DESIGN COLLABORATIVE

29 April 2013
Ref: 130168.1L

Re: Submission – SSD 5249-2012, Mixed Use Development, 1 Lawson Square, Redfern

DRAWING:
OVERSHADOWING ANALYSIS – SHEET 2
DRAWING No:
DA – 1504
JOB No:
5578
ISSUE:
B

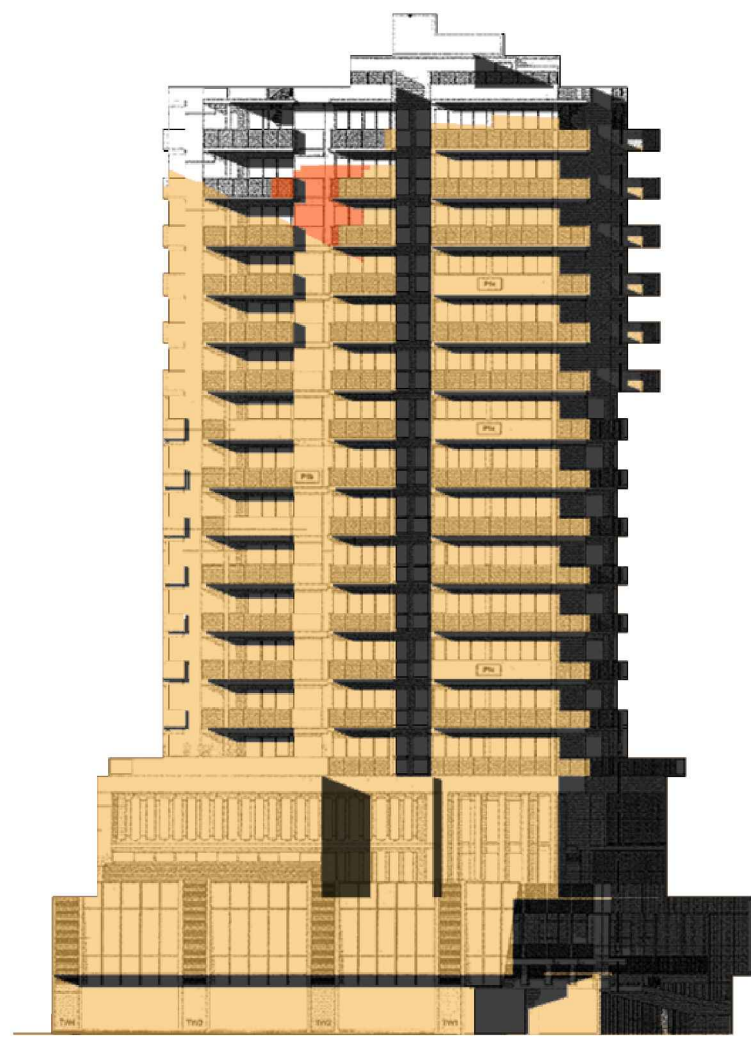
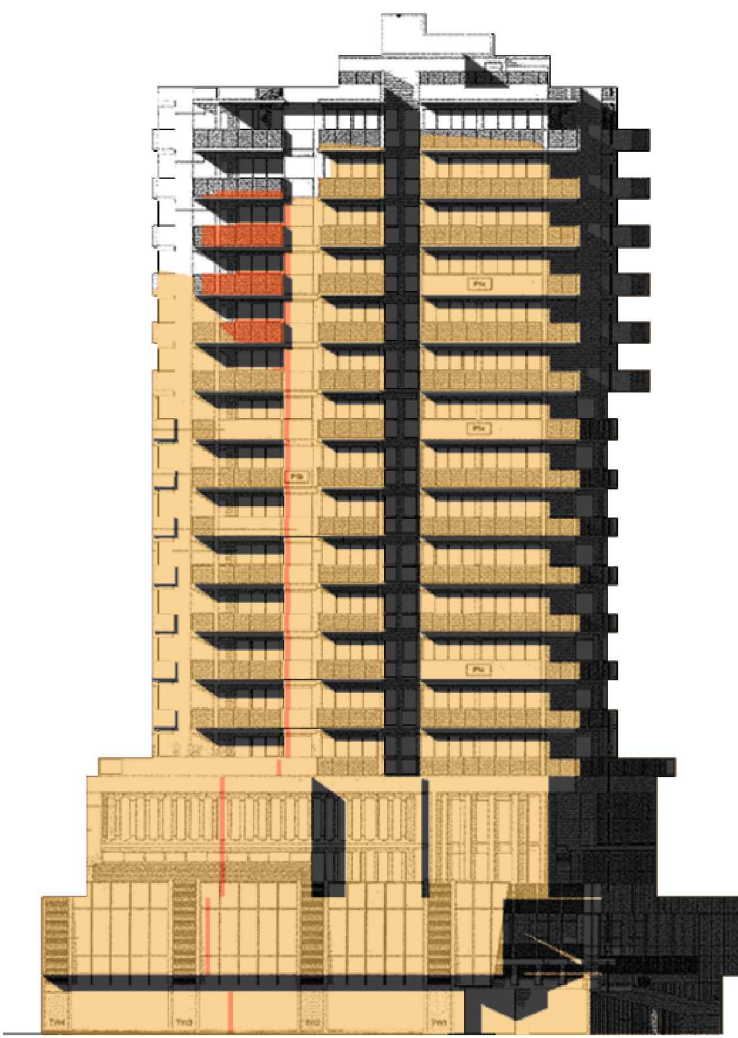
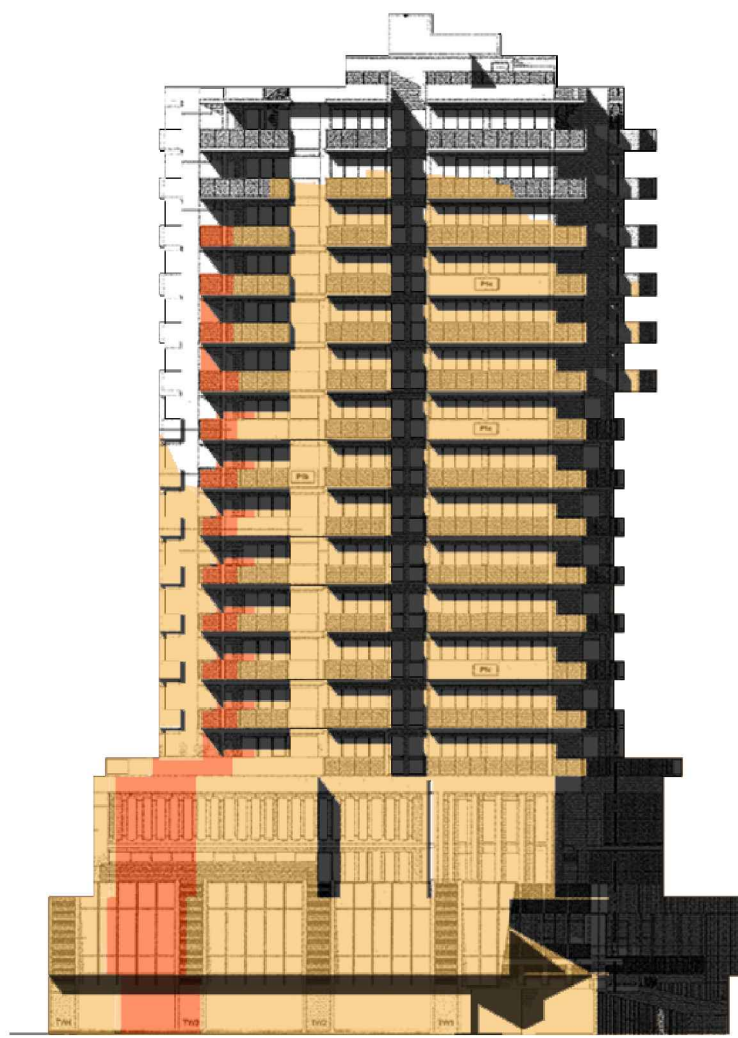
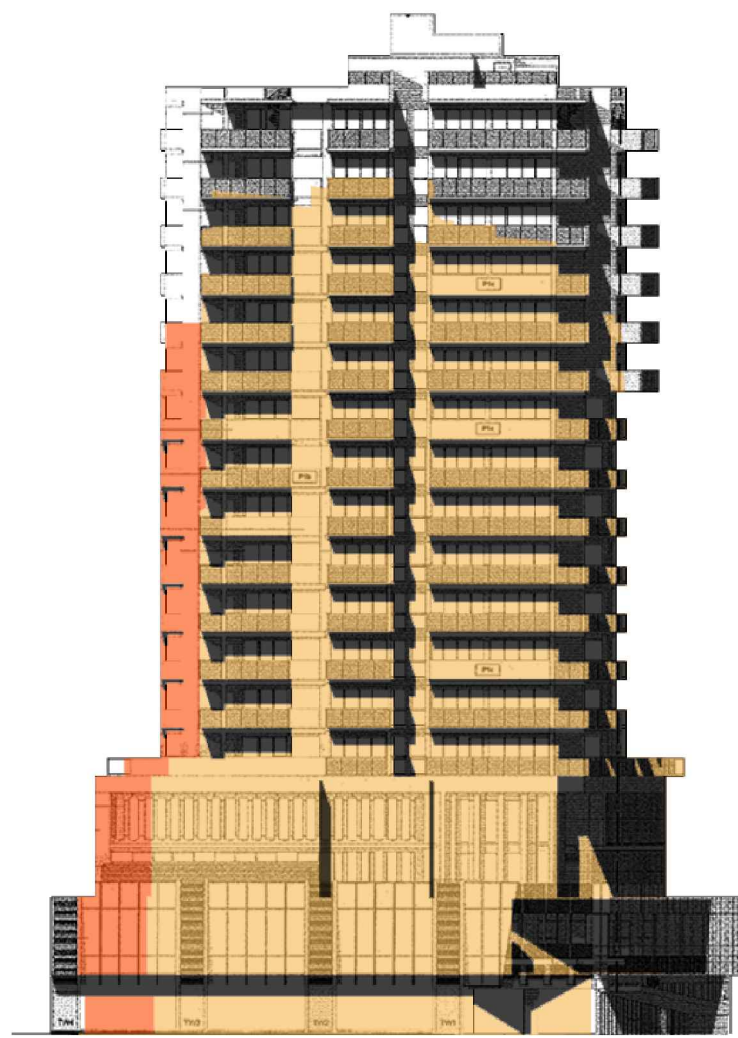
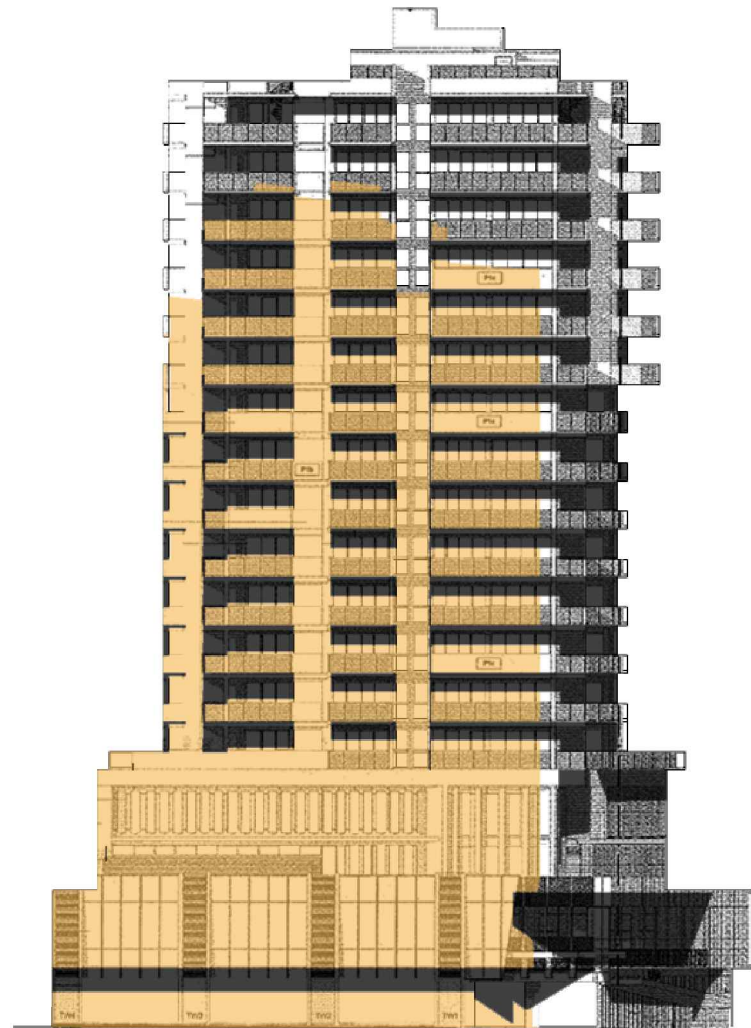
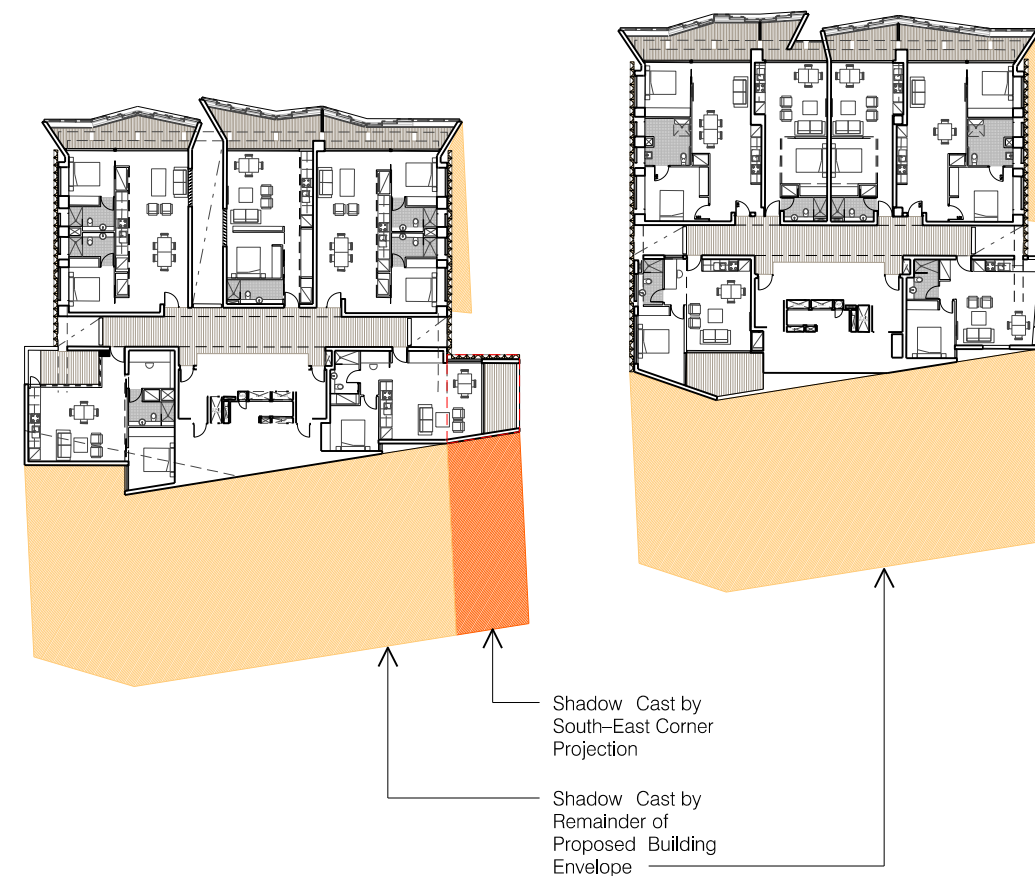
The documentation for the proposed development, in our opinion, has not demonstrated why the proposal should be supported. Most notably it fails to provide the necessary justification for the variation to the floor space standard and building heights, especially as there are severe impacts with respect to view loss of the existing panoramic views of the Sydney City CBD and loss of solar access to a bedroom of apartment 1803. These issues are dealt with below.

It is clearly not the case that no substantive adverse impacts arise from the non-compliant FSR proposed. Loss of existing panoramic Sydney City CBD views and loss of solar access to a bedroom of apartment 1803 are substantive adverse impacts directly attributable to the non-compliance with the with the FSR standard of 7:1. On this basis alone the application must fail.

Based on the above, we have concluded that the subject application should be refused. We have formed the view that the proposed development will have significant adverse impacts on our clients' existing views of the Sydney City CBD directly attributable to the non-compliance with the floor space ratio controls and height controls as detailed in this submission and loss of solar access to the bedroom of apartment 1803.
